Town & Country Planning Act 1990 (as amended)
Town & country Planning (Development Management Procedure) (England) Order 2015
Application for Planning Permission for Works or Extension to a Dwelling

Development Proposed alteration to rear/south elevation revising previous application ref: AW/332/13 reducing area of work to be carried out.

Location Tradewinds 7 Arun Way Bognor Regis

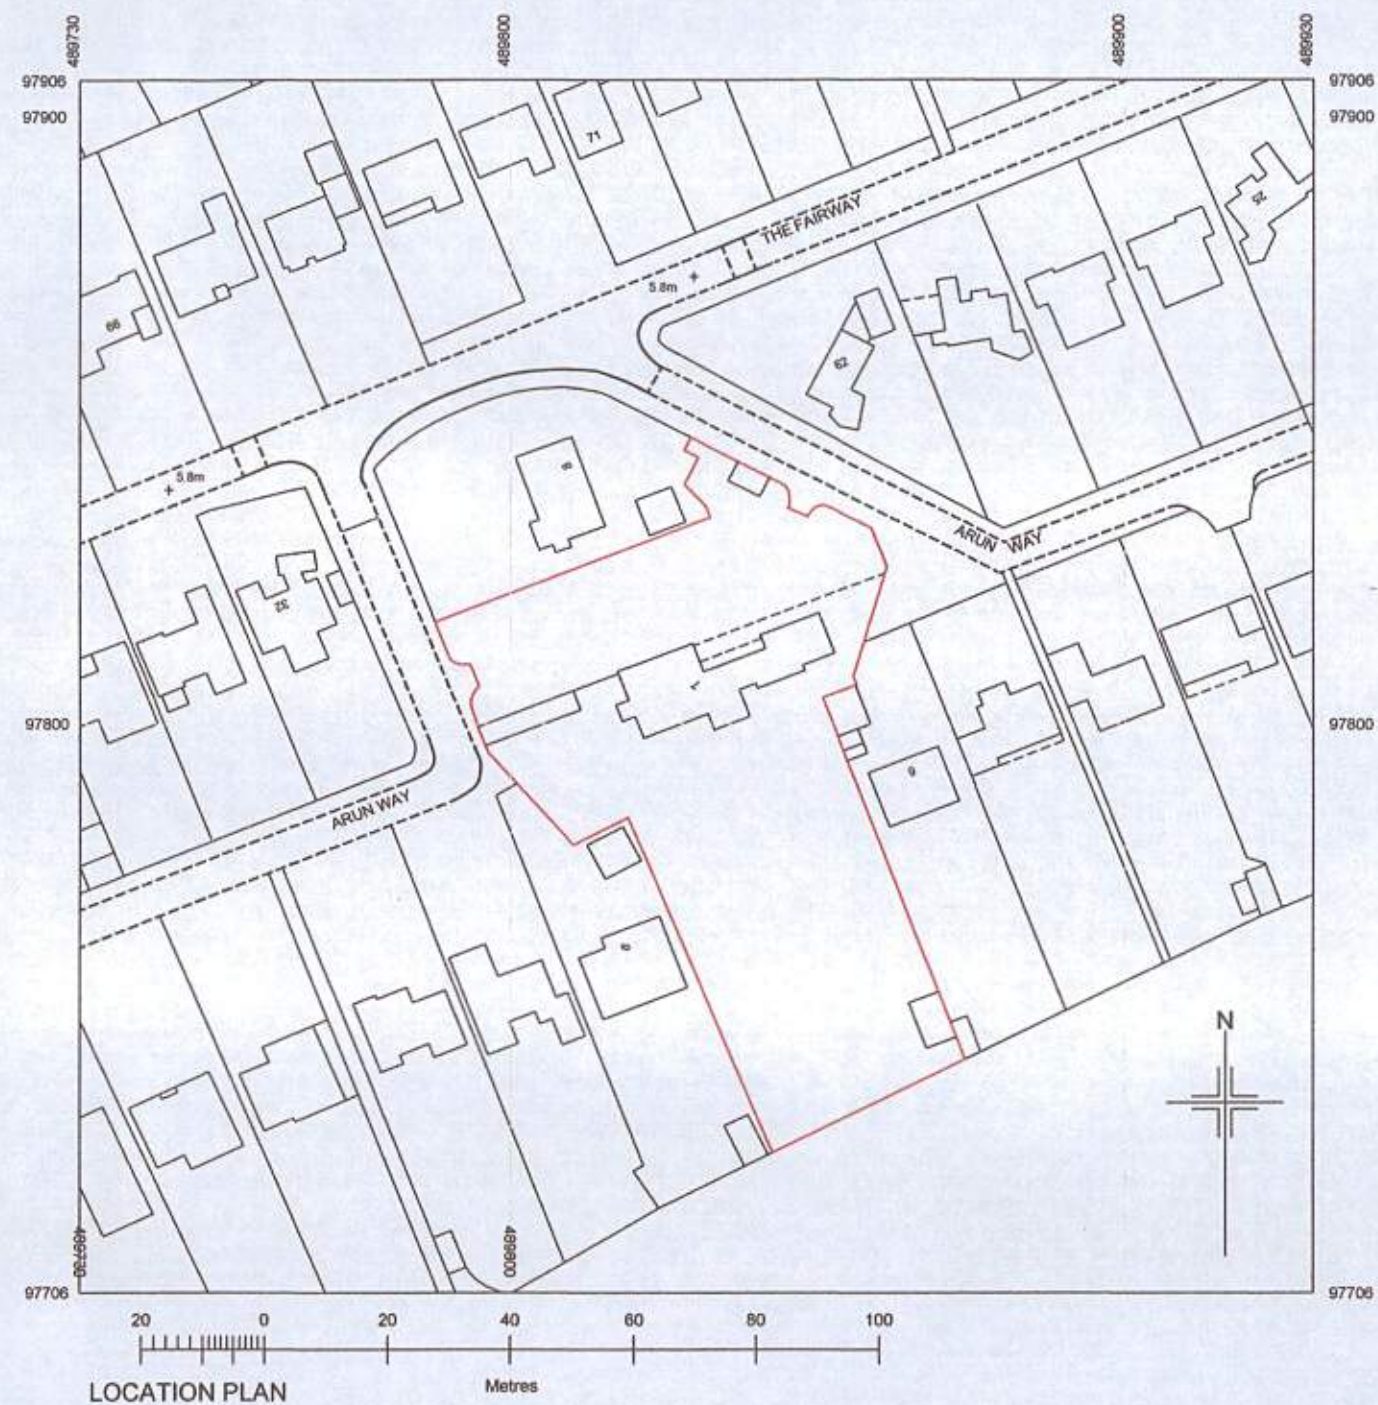
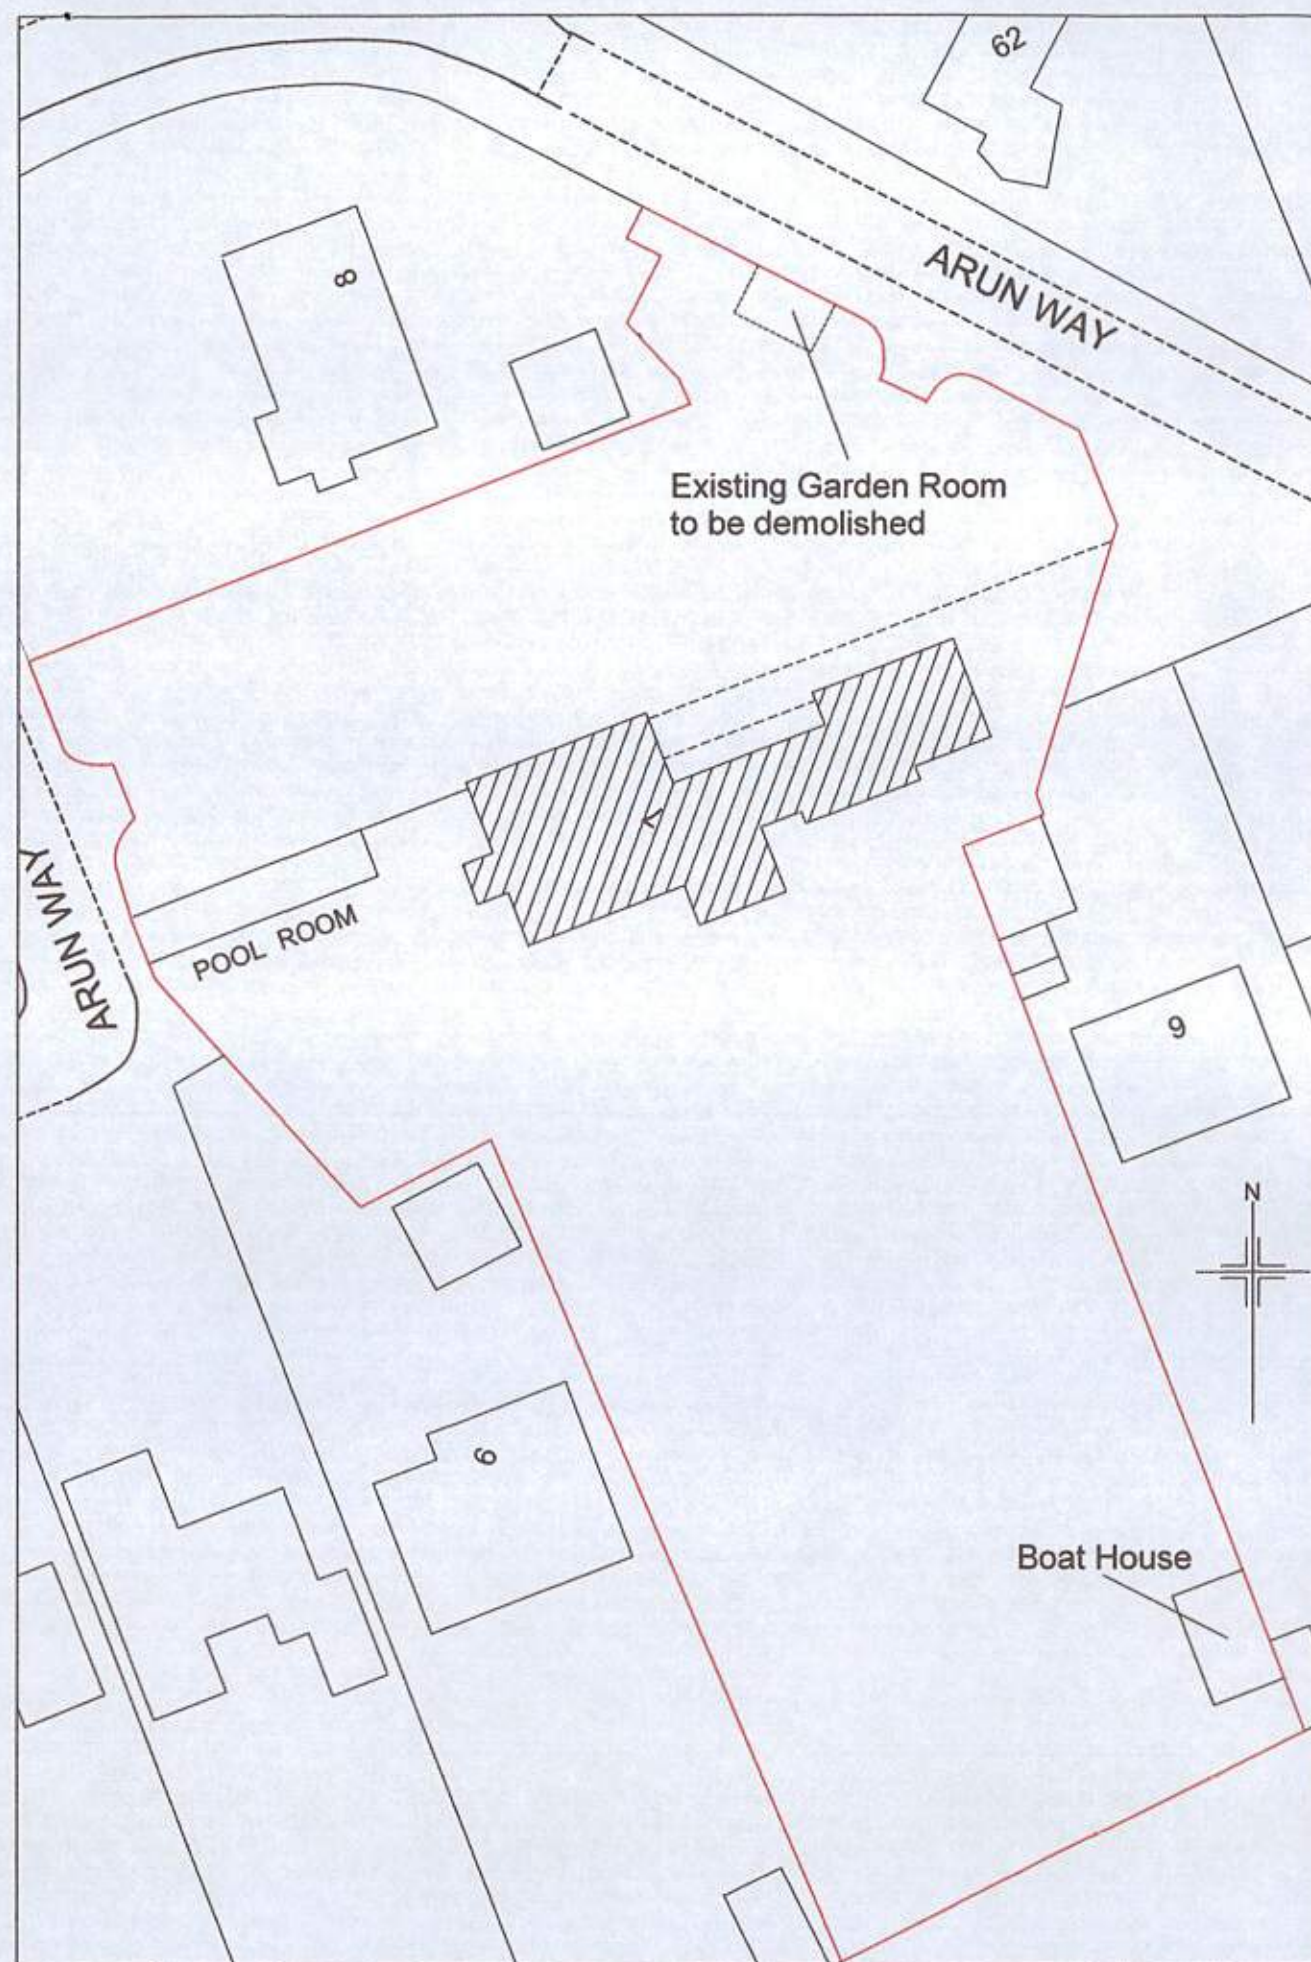
The scale on the location and block plan is incorrect. Please resubmit revised plans with the correct scale on.
